Recommendation Report for Planning Permission for Works or Extension to a Dwelling

REF NO: R/5/21/HH

LOCATION: 22 The Martlets
Rustington
BN16 2TY

PROPOSAL: Single storey side extension.

Revision	Date	Description
Client:		
Mr & Mrs S Rouse, 22 The Marlets, Rustington		
Project:		
Side Kitchen Extension		
Drawing Title:		
Proposed Plan and Elevations		
Scale:	Date:	Drawn By:
1:50	31/12/2020	BE
Drawing Number:	Revision:	
1415/003	-

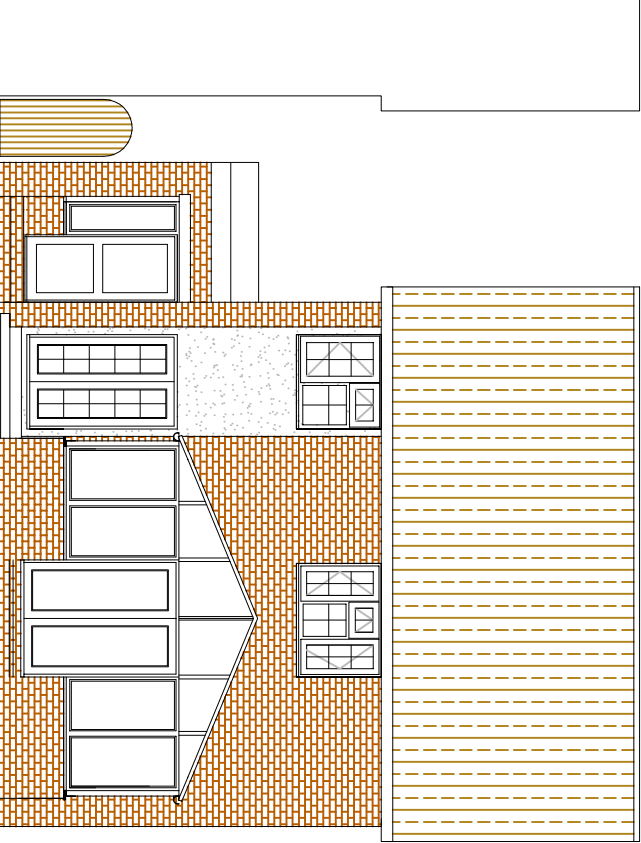
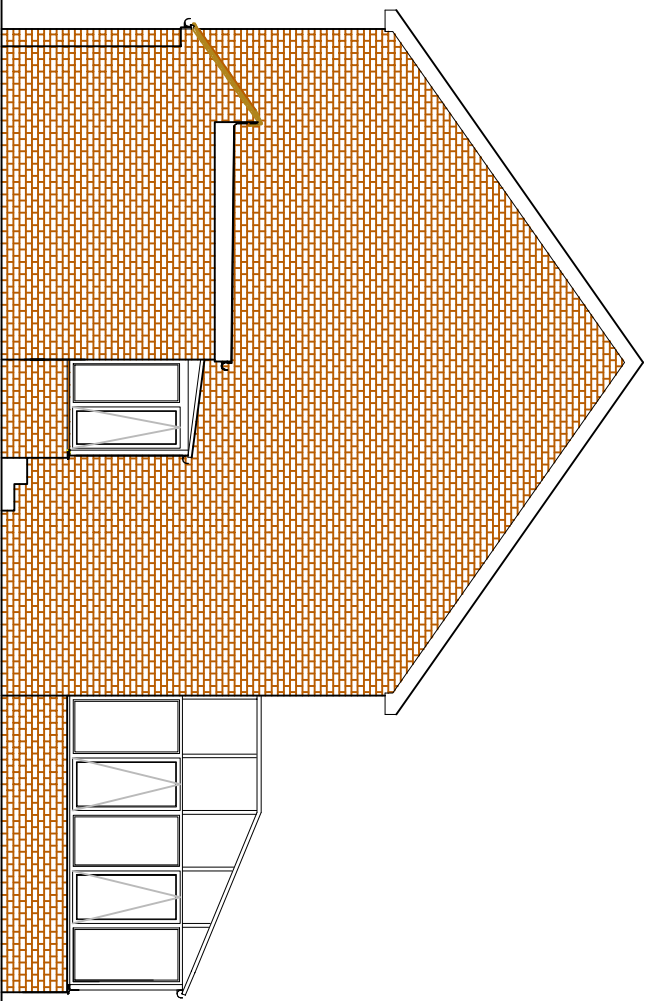
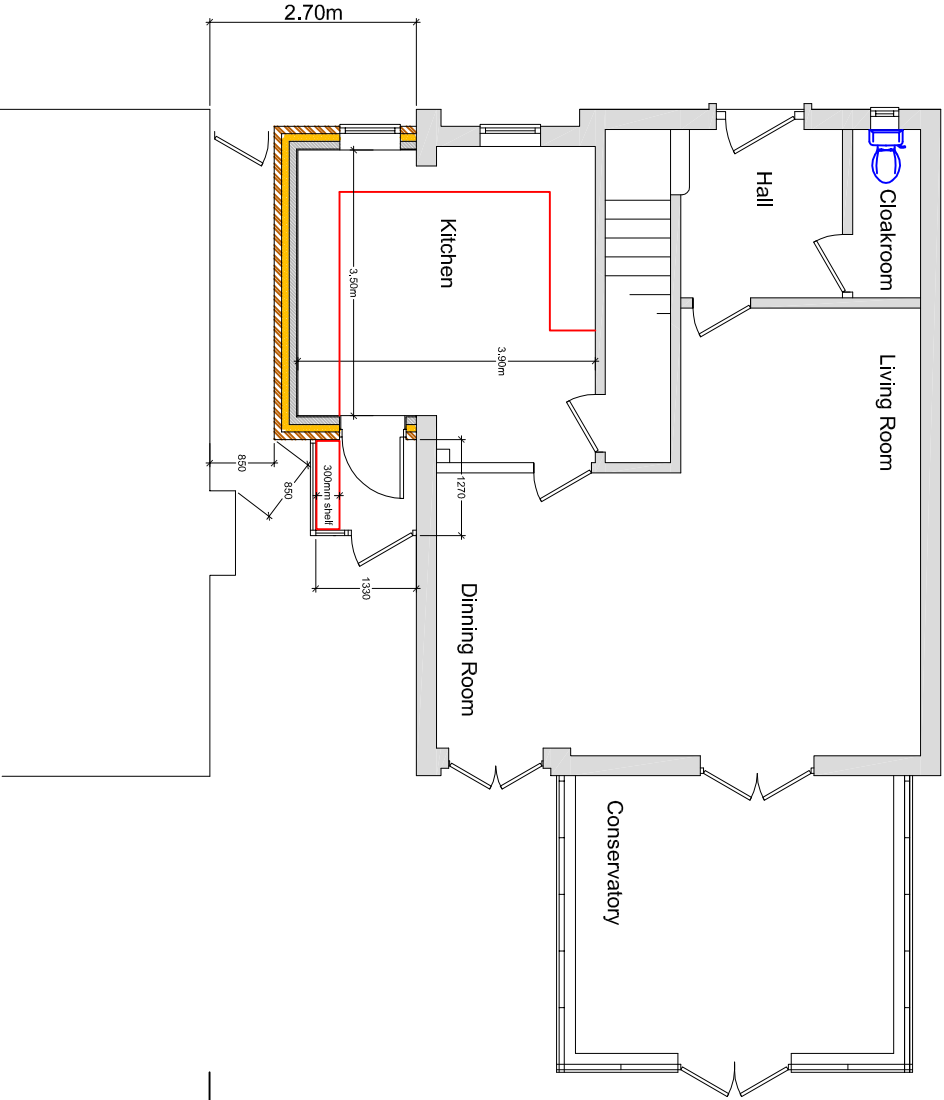
DESCRIPTION OF APPLICATION A side extension at the front of the house 1.85 metres in depth 3.5 metres in length with a height of 3.38 metres and an eaves height of 2.3 metres

Due to the siting of the proposed development, the extension can be viewed within the public realm. It is acceptable due to its location set back from the road, matching materials and a reasonable scale and massing. Furthermore, due to the modest scale of the extension and its design, it is considered to be a subservient, and well integrated extension to the host dwelling. As a result of these factors, the proposed development is considered to accord with D DM1, D DM4(a), (b) and (e) of the Arun Local Plan, Policy 2 of the Rustington Neighbourhood Development Plan and Section M of the Arun Design Guide.

The proposed development is not considered to result in any harmful overbearing or overshadowing impact upon the occupiers of neighbouring dwellings. This is as a result of the siting of the development and its modest scale. These factors allow for the portion of the development of which is close to the Western boundary of the application site to match the side flank wall of the neighbour to the West, which represents a standard side-to-side relationship, and mitigates any potential for harmful impacts. With regard for potential for loss of privacy, due to the single storey nature of the proposal, the extension cannot be considered to provide views of which are any different to those from the application site at current. As a result of these factors, the application is considered to be in accordance with D DM1(3) and D DM4(c) of the Arun Local Plan.

Proposed Plans and Elevations dwg.no. 1415/003 dated 31/12/2020
Proposed Floor Plans dwg.no. 1415/004 dated 31/12/2020
